City of Albuquerque Stormwater Construction Site Inspection Report

Project Name and Location	Ventana Ranch Elem School Ventana Hills & Universe		
Site Contact Name & Agency	Scott Westwind	Contact Phone #	SOS 328-0945
Date of Inspection	3-16-16	Start/End Time	11:10 / 11:45
Inspector Name, COA Dept.	Curtis Cherne, Stormwater Quality		
Inspector Phone / E-mail	505-924-3420/ccherne@cabq.gov		
Inspector Qualifications	Qualified Compliance Inspector of Stormwater- Stormwater One		
Describe Present Phase of Construction	Stabilized

EROSION AND SEDIMENT CONTROL PLAN

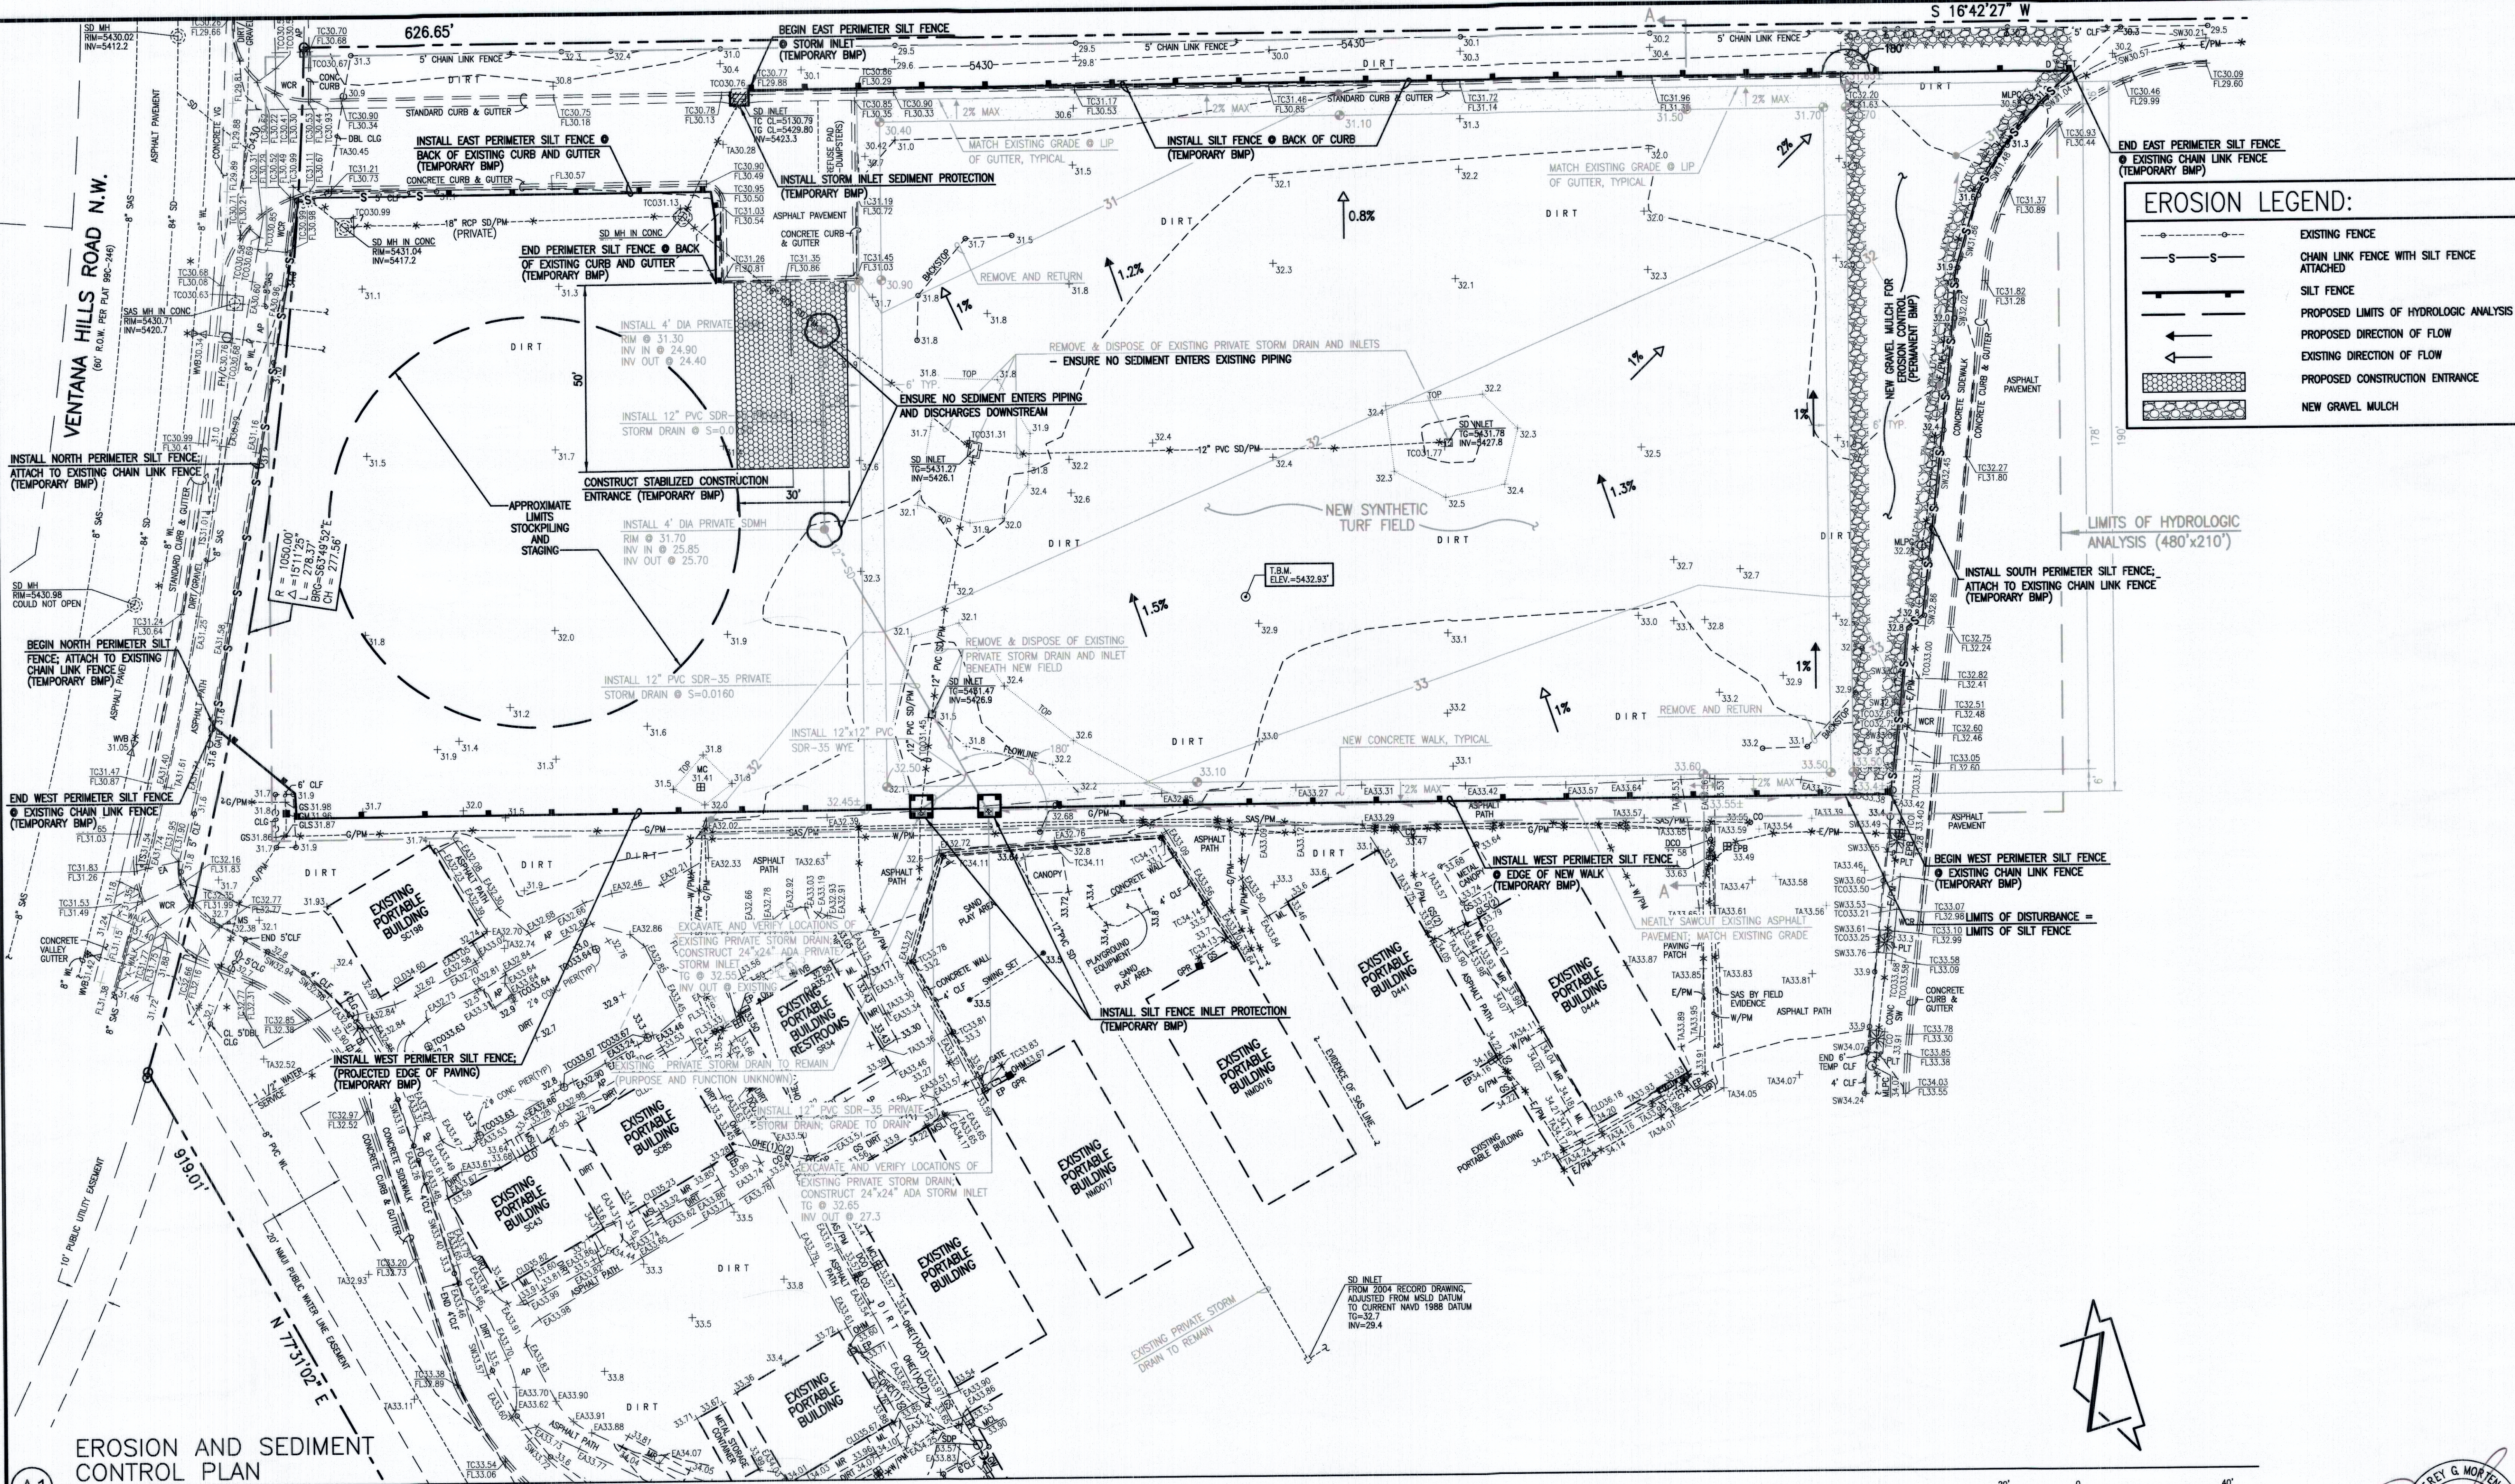
On the Ventana Ranch ES ESC plan, should the entrance be shifted north a bit so the inlet isn't in the rock entrance?
If the rock is to remove dirt from the tires, how will they "ensure no sediment enters the inlet"?

We always specify that the Contractor shall ensure that no sediment entered the storm drain when manholes and inlets are to be constructed. In the "old days", they didn't exercise care because they could always flush the lines at closeout.

The structure proposed beneath the stabilized construction entrance is a manhole, not an inlet. We anticipate that the contractor will build the inlet early, but not raise it to grade until all grading is complete. The location for the construction entrance was coordinated with the Contractor based upon the ability turn trucks. Moving the construction entrance north will make turning movements much more difficult and likely result in a field change. The location also is focused on the proposed stockpile location.
